Application No: EP/142/21/HH
Site Address: 38 Vermont Drive East Preston BN16 1LG
Description of works: Conversion of roofspace to habitable use to include 2 x side dormers, Juliet balcony and conversion of roof from hip to gable end and single storey ground infill extension.

Thank you for your internet representation made on 2nd December 2021 which has been recorded as an objection with the comments as follows:

ARW Design	DRAWING TITLE: PROPOSED ELEVATIONS PROJECT: PROPOSED LOFT CONVERSION WITH HIP TO GABLE END & DORMERS TO SIDE ELEVATIONS		LOCATION: 38, VERMONT DRIVE, EAST PRESTON CLIENT: C. NORTH		SCALE: AS NOTED @ paper size A3 DATE: OCT 2021		DRAWING NO: 6037/2
					DRAWN: ARW		
					REVISION:

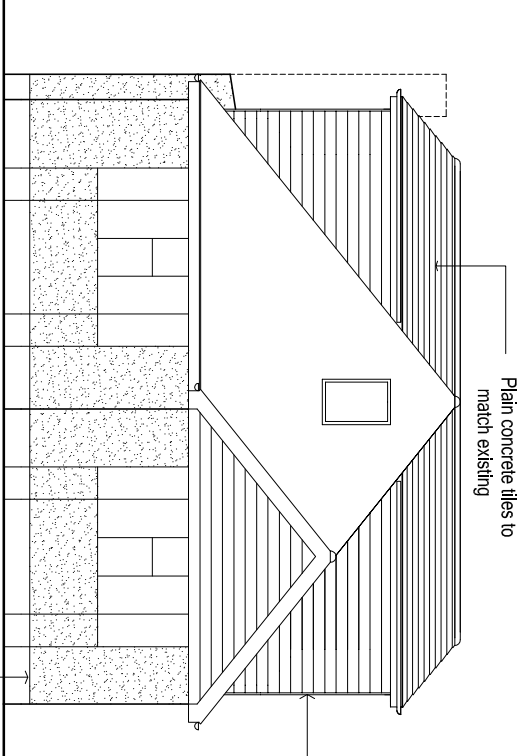
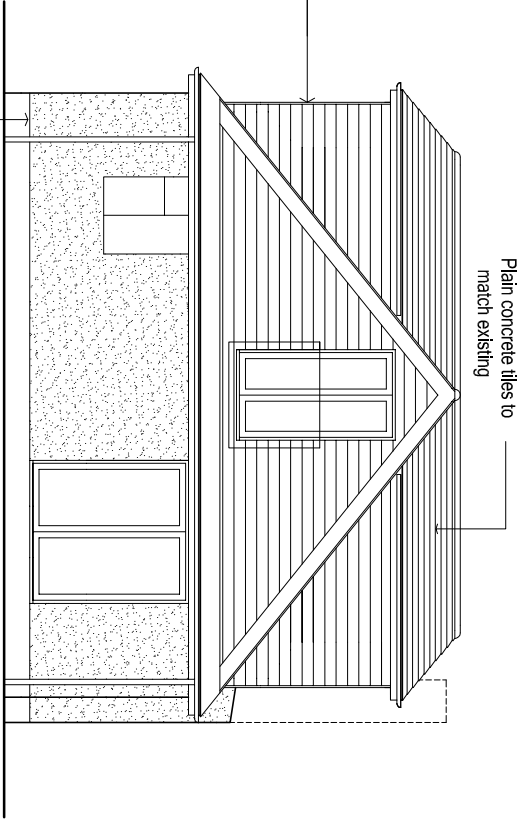
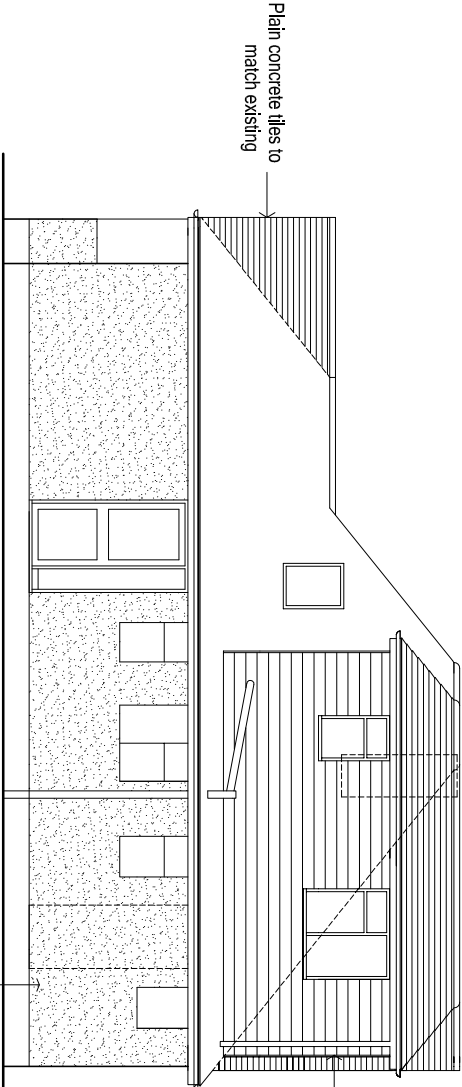
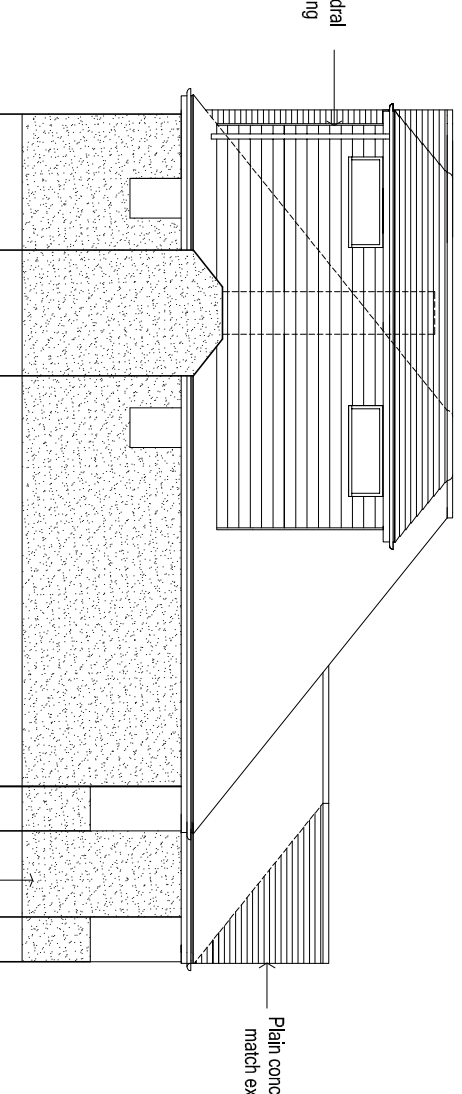
I write as Chairman of the East Preston and Kingston Preservation Society to ask that this application be refused. The two side dormers will be overbearing because of their size and position relative to the roof ridge and eaves. Even though they would be situated towards the rear of the house, they would still be visible from the street from the east, north and west, presenting an unbalanced profile overwhelming this small bungalow. From the street view, the proposals would result in an unacceptably rectangular profile. The unbalanced side views would also be exacerbated by the proposed hip to gable change to the front elevation. In addition, the materials proposed (render of unspecified colour, and light grey cladding) would not harmonize with the majority of attractive small brick bungalows in this area. We would therefore ask that this application be refused as contravening Policy D DM4 of the Local Plan; Section M (Roof Extensions - Loft Conversions/Dormers) of the Arun Design Guide and Policy 1i of the East Preston Neighbourhood Plan.
